Southampton to London Pipeline Project

Responses to ExA's Further Written Questions -
Alternatives (ALT)

Application Document: 8.33

Planning Inspectorate Reference Number: EN070005

Illustration 3.2: Aerial photography of TC 38 in Fordbridge Park

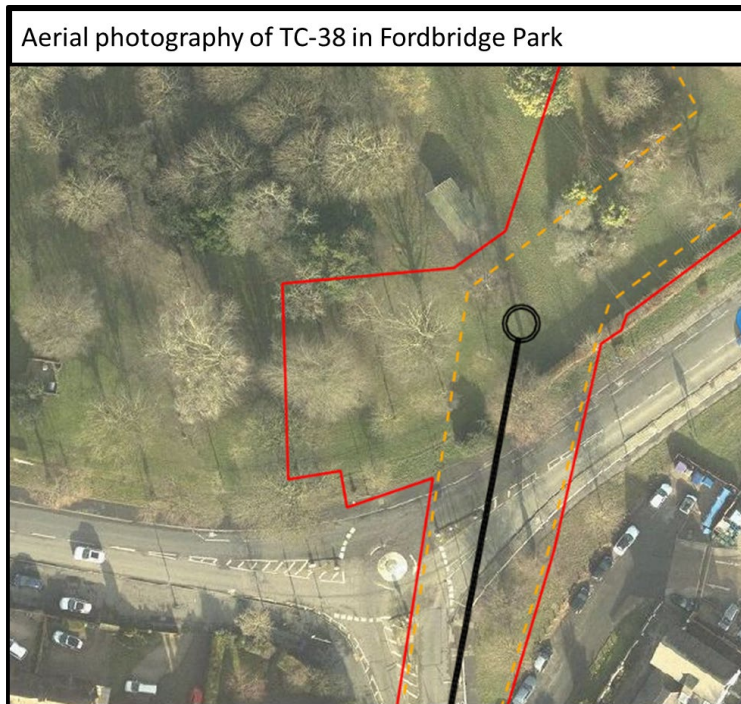
ExQ2	Question:	Applicant response to Question:
ALT.2.1	In the Examining Authority's Written Question (ExA WQ) ALT.1.4 [PD-008], the ExA requested the Applicant consider trenchless crossing for the whole of Fordbridge Park. The ExA notes the Applicant's response [REP2-038]. However, at the Issue Specific Hearing (ISH) held on Tuesday 3 December 2019 [EV-009a and EV-009b] the ExA expressed its concerns that the route of the proposed pipeline along the only tree-covered part of the park would have a considerable effect on its character.	<p>1.1 The Applicant does not agree that <i>the route of the proposed pipeline is along the only tree covered part of the park</i>. Approximately 50% of Fordbridge Park is tree covered with the most dense areas of tree cover being to the north of the proposed Order Limits. In selecting the route, the Applicant has considered a wide number of constraints. In the more open southern part of the park there are the high voltage overhead power lines, two buried high voltage lines and a gas main. In addition, this open area is popular for recreational use. The Applicant has therefore selected a route alignment which largely passes north of these constraints and along the southern boundary of the trees.</p> <p>1.2 The Applicant does not agree that the work in Fordbridge Park will have a 'considerable effect on its character' – this is supported by the answers to points i), ii) and iii) below.</p> <p>1.3 In response to i), Fordbridge Park has been identified as a potential 'hotspot' and the Applicant is submitting a Site Specific Plan (Document Reference 8.59) at deadline 4. This provides detail of the Applicant's intended pipeline alignment, working area and the trees that it expects will require removal; and is informed by a tree survey.</p> <p>1.4 In response to ii), the Site Specific Plan (Document Reference 8.59) for Fordbridge Park contains the information on which trees will require removal. The Applicant believes that with the current intended alignment the open trench section would require the removal of four trees and the trenchless working area would require the removal of two trees. Detailed design of the trenchless crossing will further consider the options to retain these two trees. None of these trees are mature and none are identified as memorial trees.</p> <p>1.5 In response to iii), the Site Specific Plan (Document Reference 8.59) takes account of the commitments applied across the project which will be used to protect the trees in Fordbridge Park.</p>

ExQ2	Question:	Applicant response to Question:
	<p>i) Explain whether additional surveys have been carried out and whether the narrow working width could be specifically defined.</p> <p>ii) Confirm the number of trees that would be removed in the trenched section of Fordbridge Park.</p> <p>iii) Explain the preventative measures that would be undertaken to protected trees and how they would be secured in the draft Development Consent Order (dDCO) [REP3- 006].</p>	<p>(For clarity with regards to the question, there are no protected trees in Fordbridge Park), which include the following:</p> <ul style="list-style-type: none"> • Article 41(2) obliges the Applicant not to cause any unnecessary damage to any tree, shrub or hedgerow. • NW30: <i>'Narrow working width reduced to 10m where possible to avoid or wherever possible limit the impacts on memorial trees at Fordbridge Park. The approximate distance would be 409m. (Grid ref: TQ0620670826 to TQ0588971060)'</i>. This is secured in the CoCP. • G65: <i>'Working widths would be reduced in specific locations where trees or hedges are present. Where notable, TPO, Ancient Woodland and veteran trees would be retained within or immediately adjacent to the Order Limits, the trees and their root protection areas would be protected where they extend within the Order Limits and are at risk. This would be by means of fencing or other measures.'</i> This is secured through Requirement 12 (Landscape and Ecological Management Plan). • G95: <i>'The contractor(s) would consider and apply the relevant protective principles set out in the National Joint Utilities Group Guidelines for the Planning, Installation and Maintenance of Utility Apparatus in Proximity to Trees ('NJUG Volume 4' (2007)). This would be applied to trees within the Order Limits which would be preserved through the construction phase, and to trees outside of the Order Limits where such measures do not hinder or prevent the use of the relevant working width for construction.'</i> This is secured through Requirement 12 (Landscape and Ecological Management Plan).
